April 20, 2021

RE: Comment Response Letter – Special Use Permit – Discount Tire - Falcon (File #: AL214)

COMMENT RESPONSE LETTER

COVER SHEET  
SHEET 1 OF 3

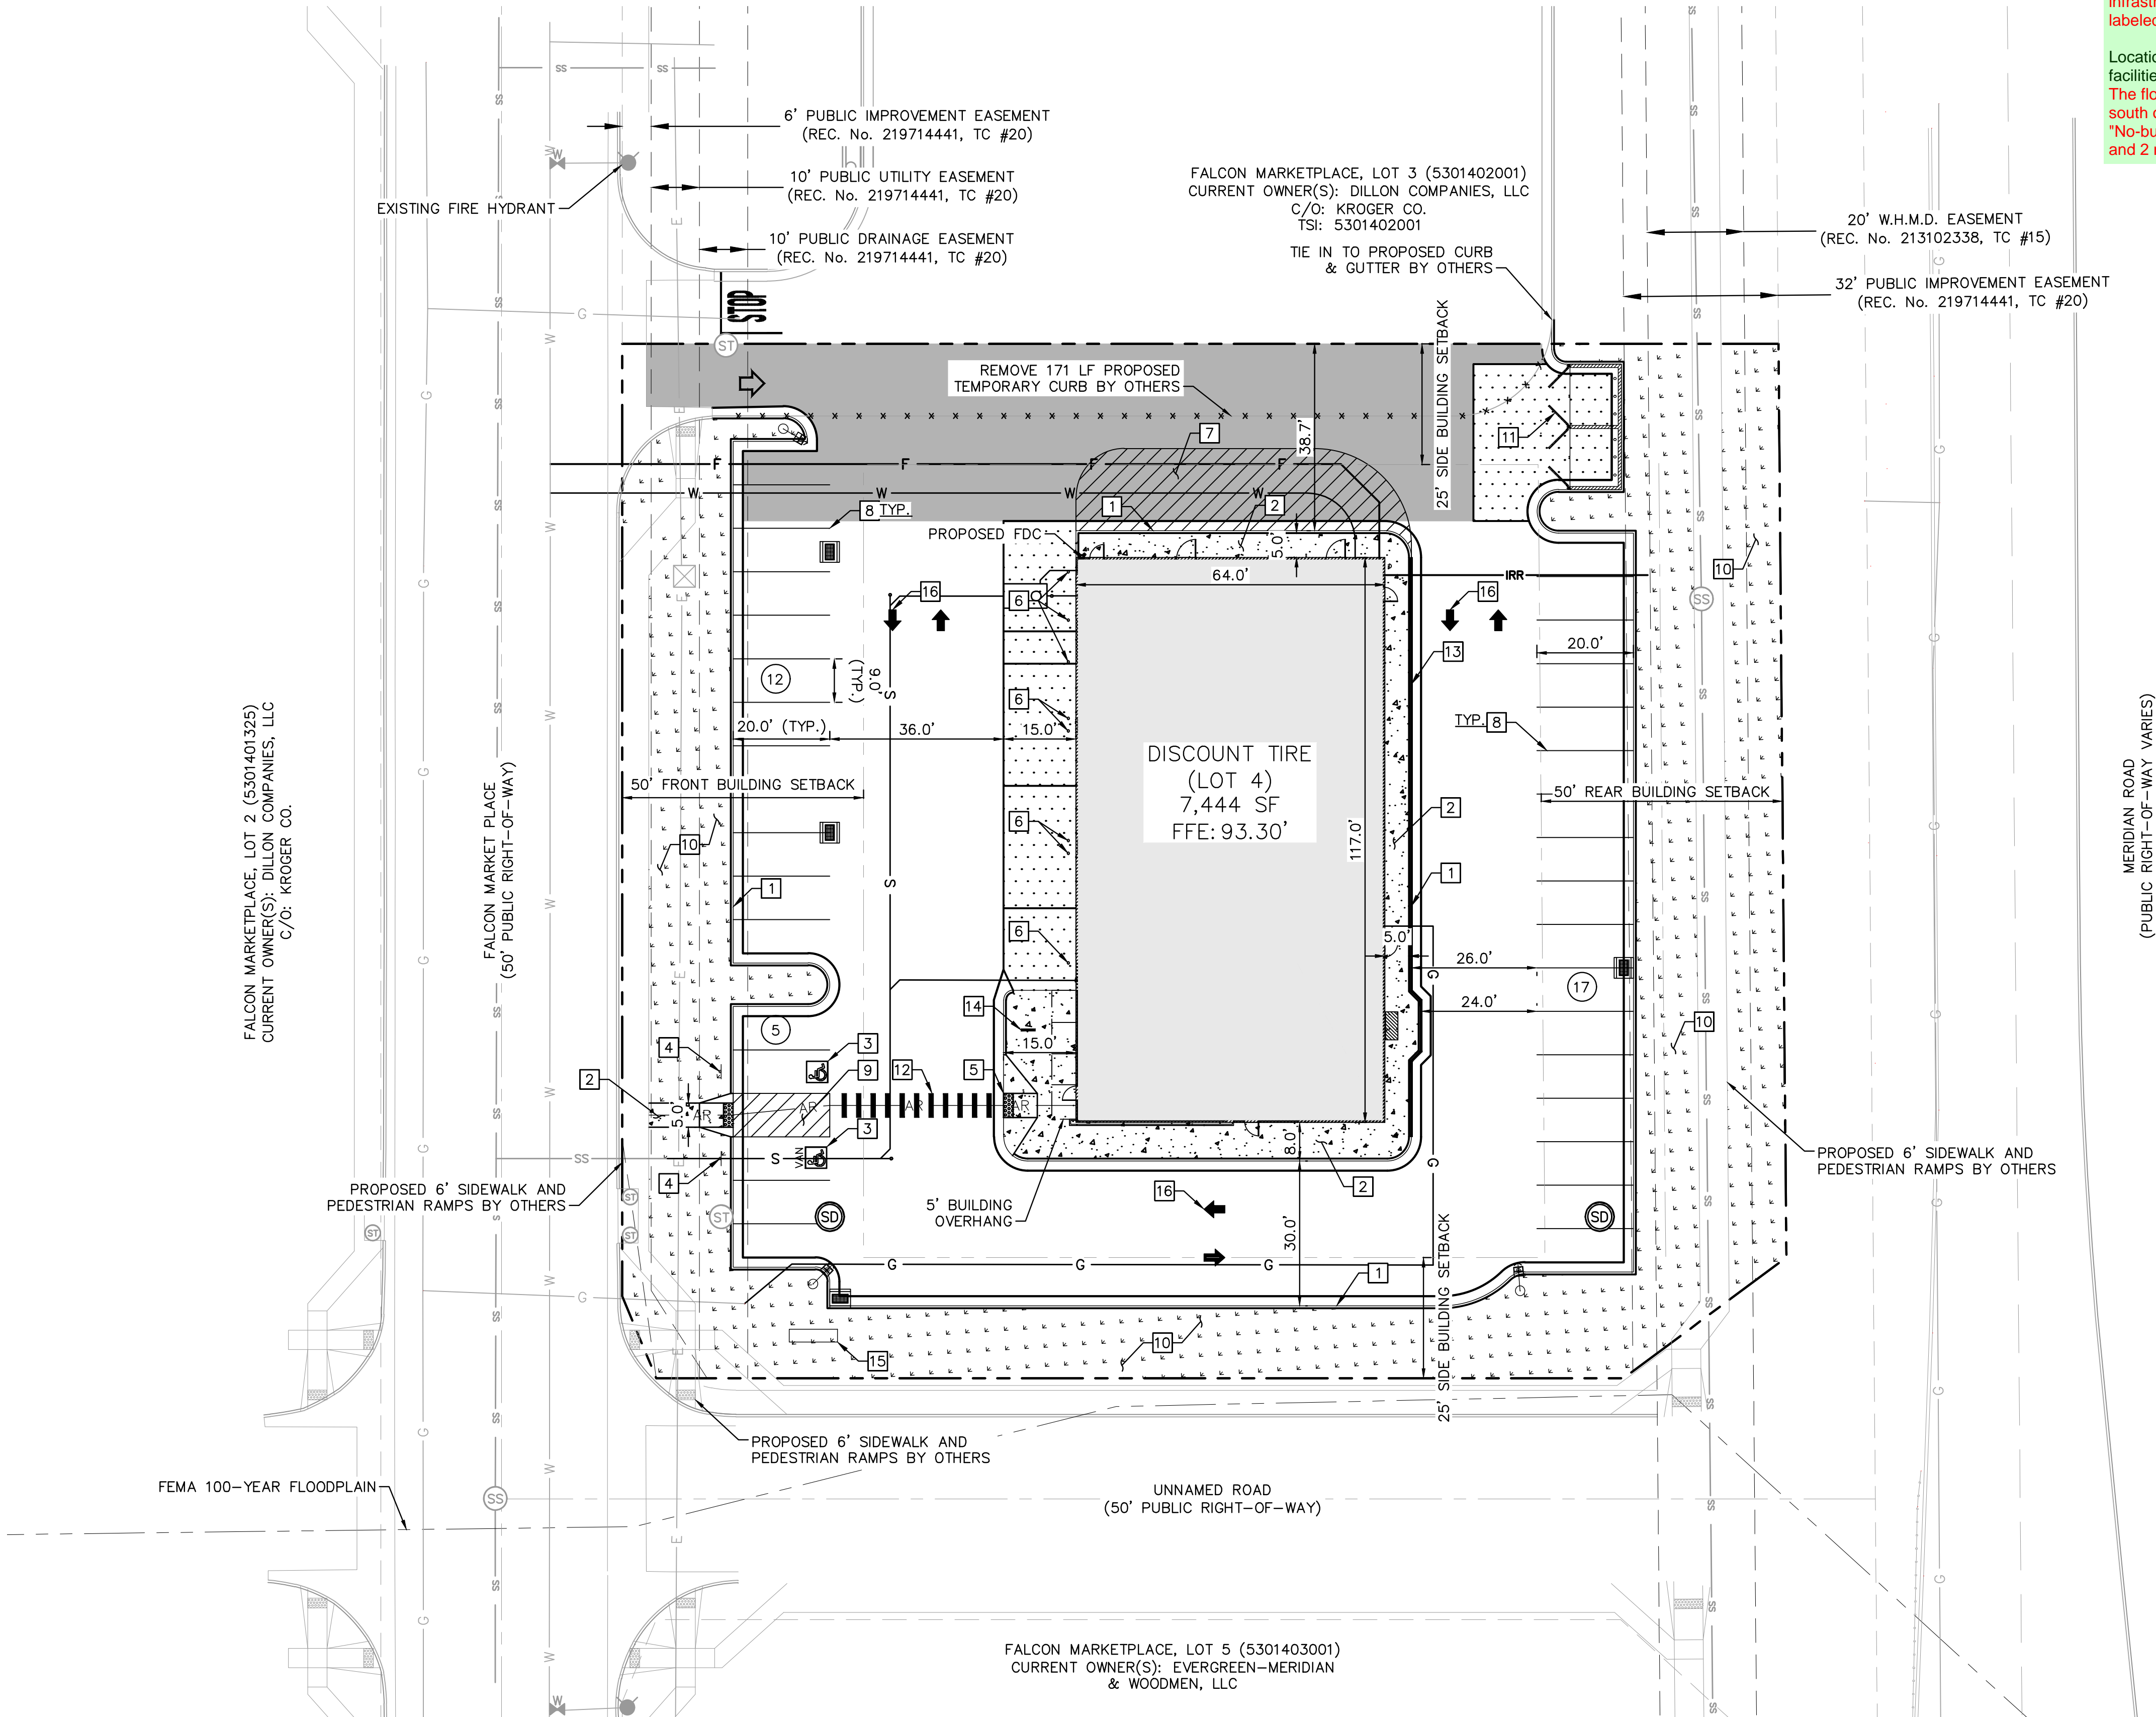
1. The site plan needs a summary table or page to include the following information:
 - *Response: Two additional sheets have been added to the site plan submittal in order to adequately show all of the required items.*
2. Please revise the reception #. The title commitment indicates this as 219714441.
 - *Response: Reception number has been updated.*
3. Please add PCD File No. AL214. If the same site plan for the special use and site development plan will be used then please also add the file no. PPR2112

- *Response: The filing numbers have been added to the coversheet.*
- 4. Where is sheet 5?
 - *Response: A separate detail sheet is now included with the site plan. Page numbers have been adjusted accordingly.*
- 5. Refer to site development plan application PPR2112 for any additional engineering comments.
 - *Response: Noted, all updates related to engineering comments will be covered on the Site Development Plan specific comment response letter.*
